32 Meadow Way  
Ferring  
West Sussex  
BN12 5LD

Nov 15 2020

Re: Objection to Application No: FG/127/20/PL (Onslow Caravan Park)

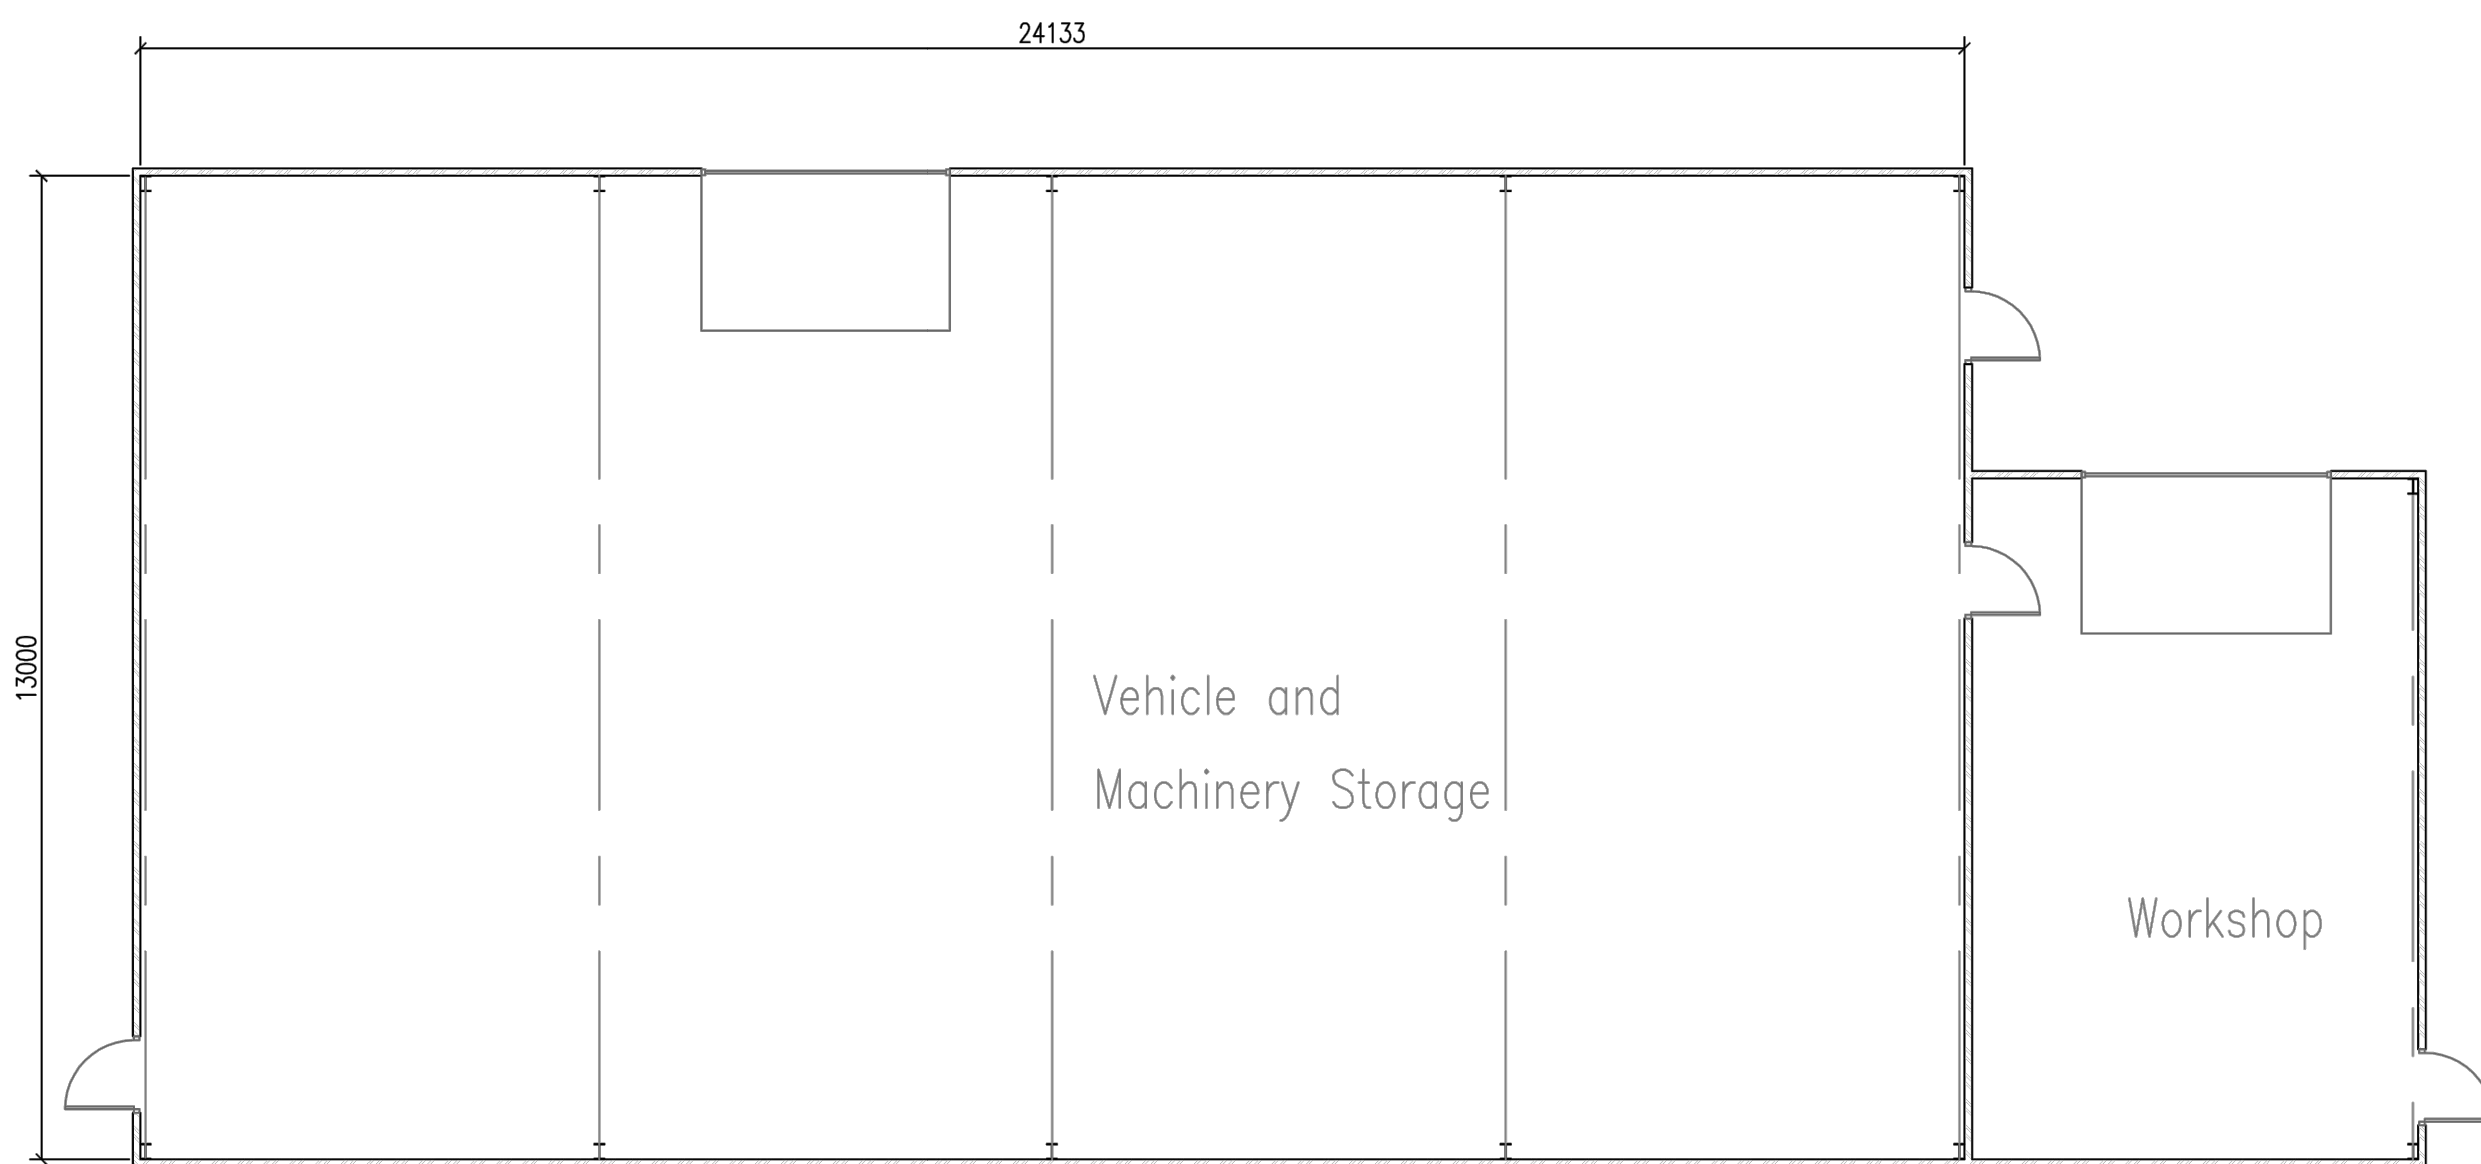
It is concerning that neither of these points were noticed when evaluating the original application. The developer's lack of transparency was then compounded when they failed to follow their own plans and built something much higher.

The workshop, euphemistically called a barn in documents, is in size and height out of keeping with the low rise character and appearance of both the caravan park and the local area. It is industrial in appearance, and is extremely overbearing from the back gardens of Meadow Way. It is unclear from the documents why the building needs to be so high. Previous applications were refused because of the height of the building; to allow the current building to remain would make a mockery of the planning system.

DRAINAGE PLAN

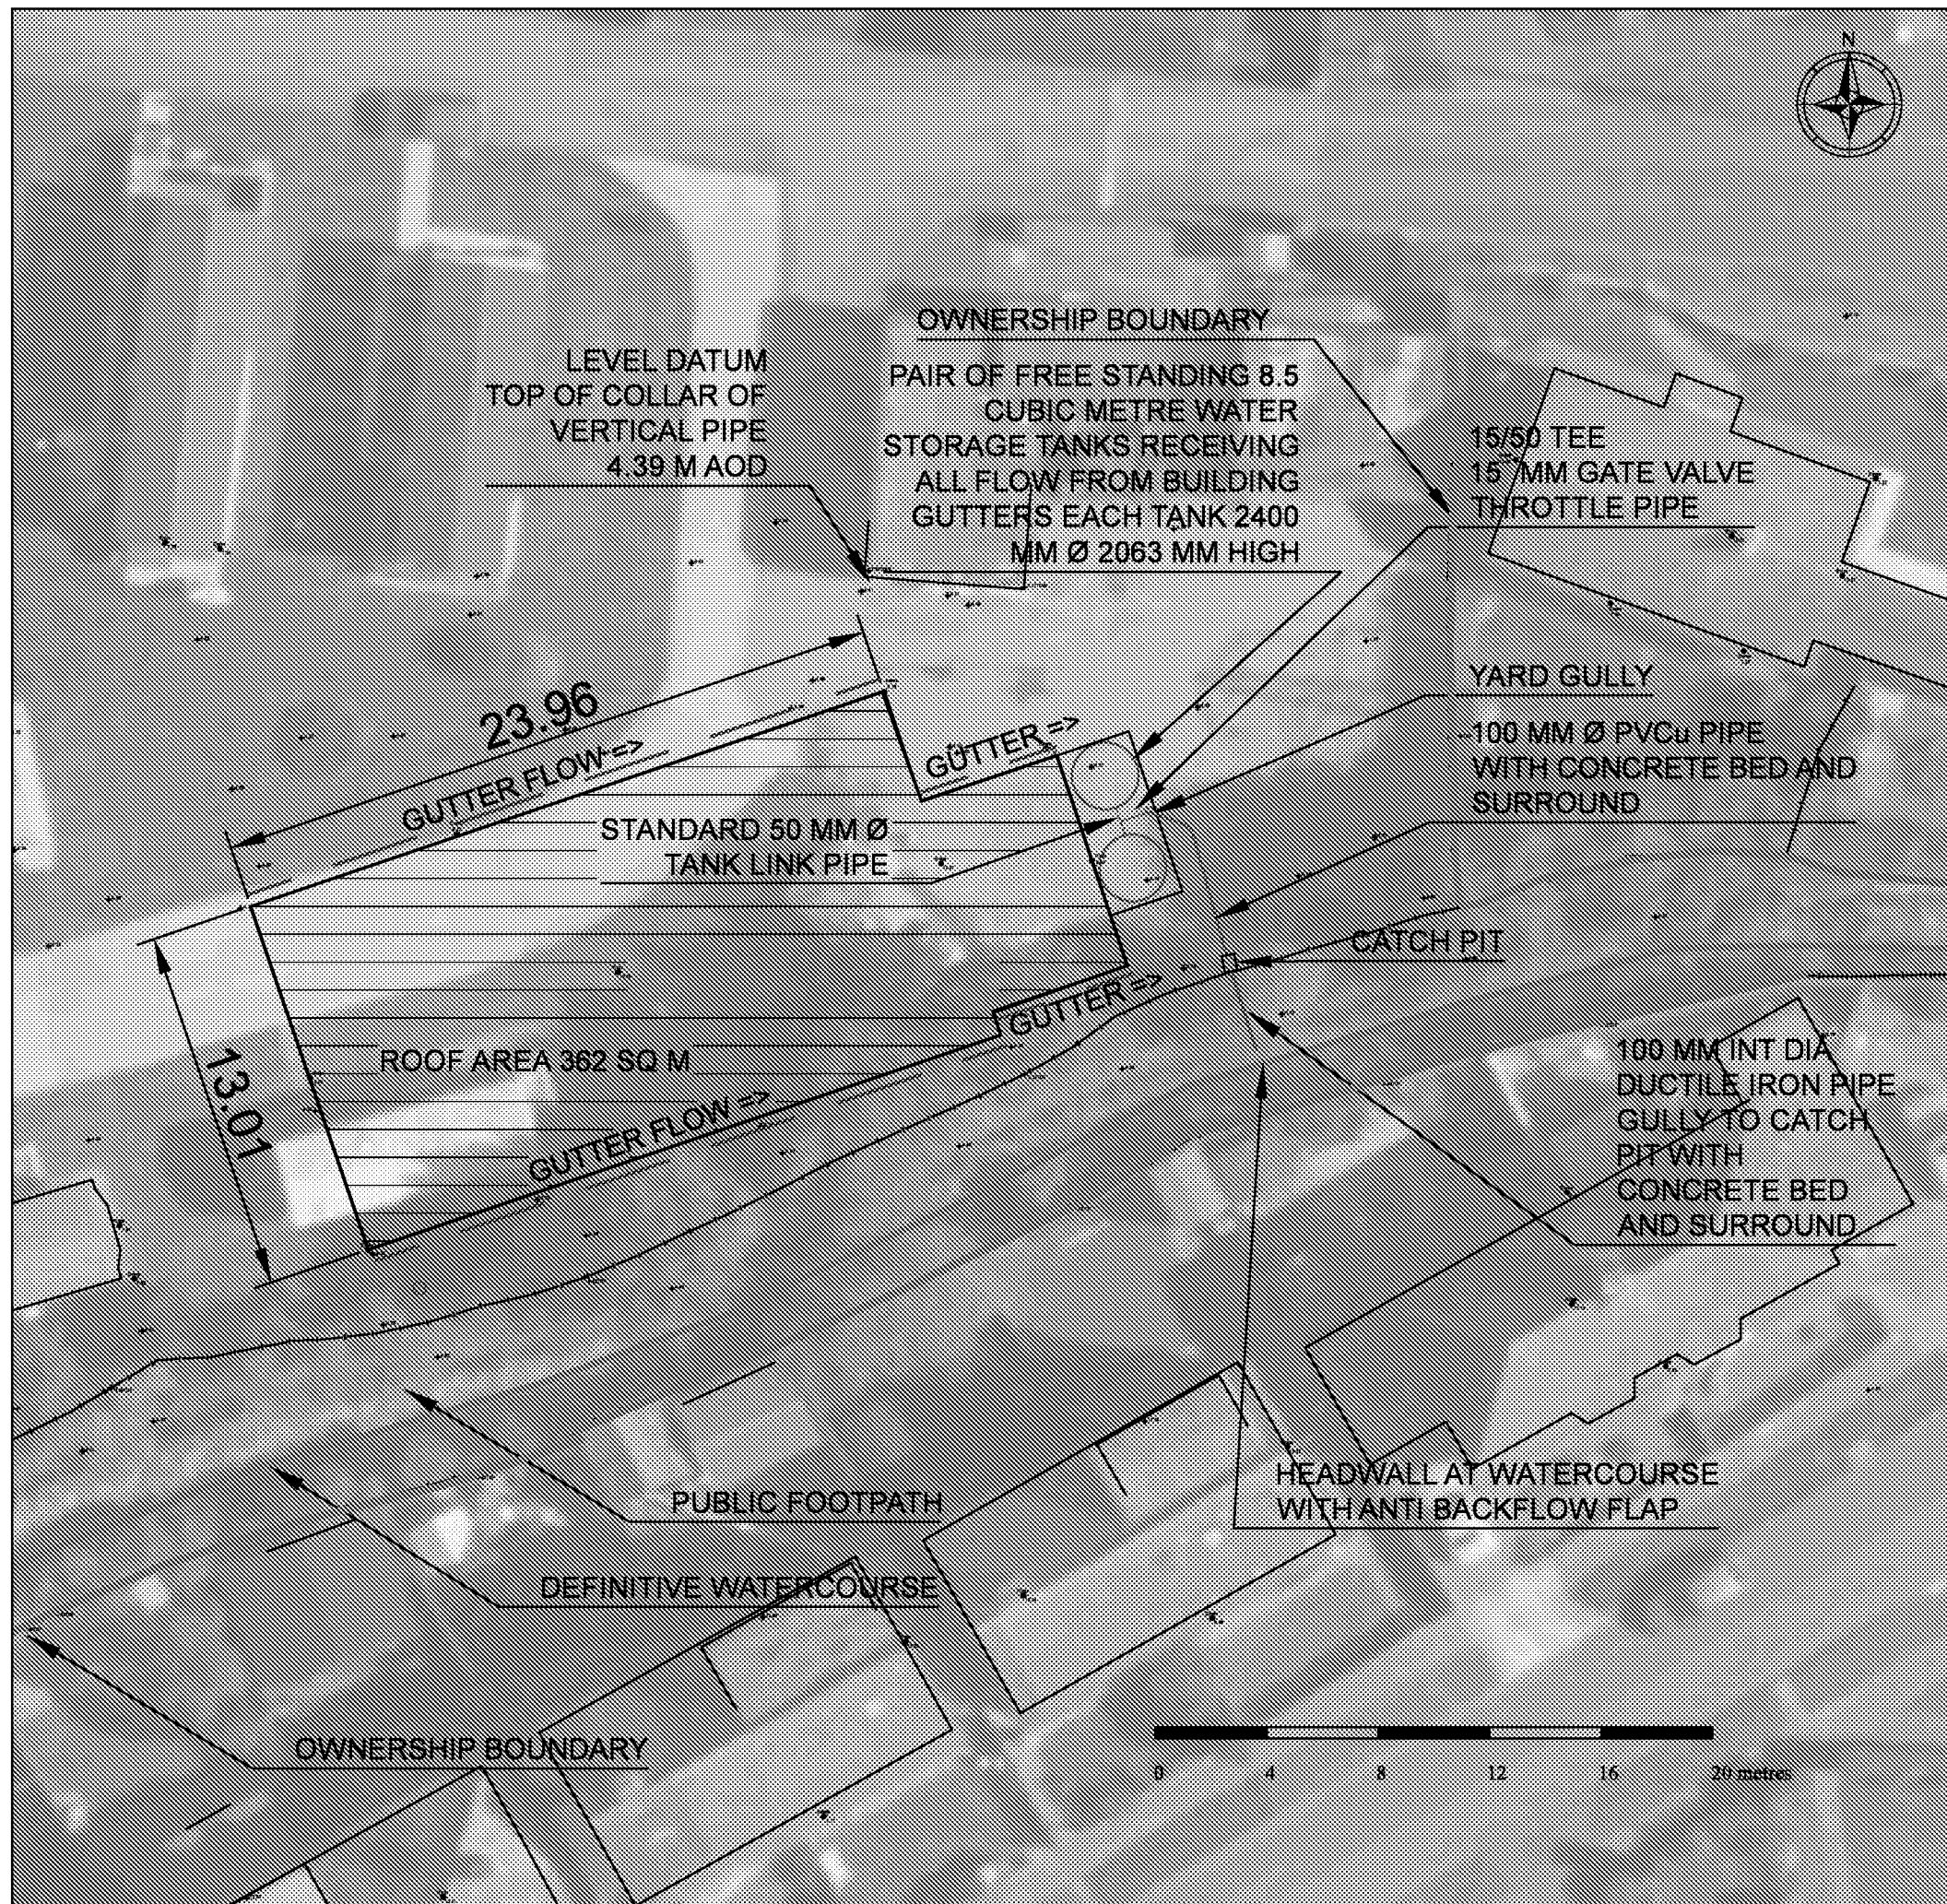
The watercourse into which surface water from this development is destined for is described in the accompanying documents as a “dry ditch”. It is anything but (see photos).
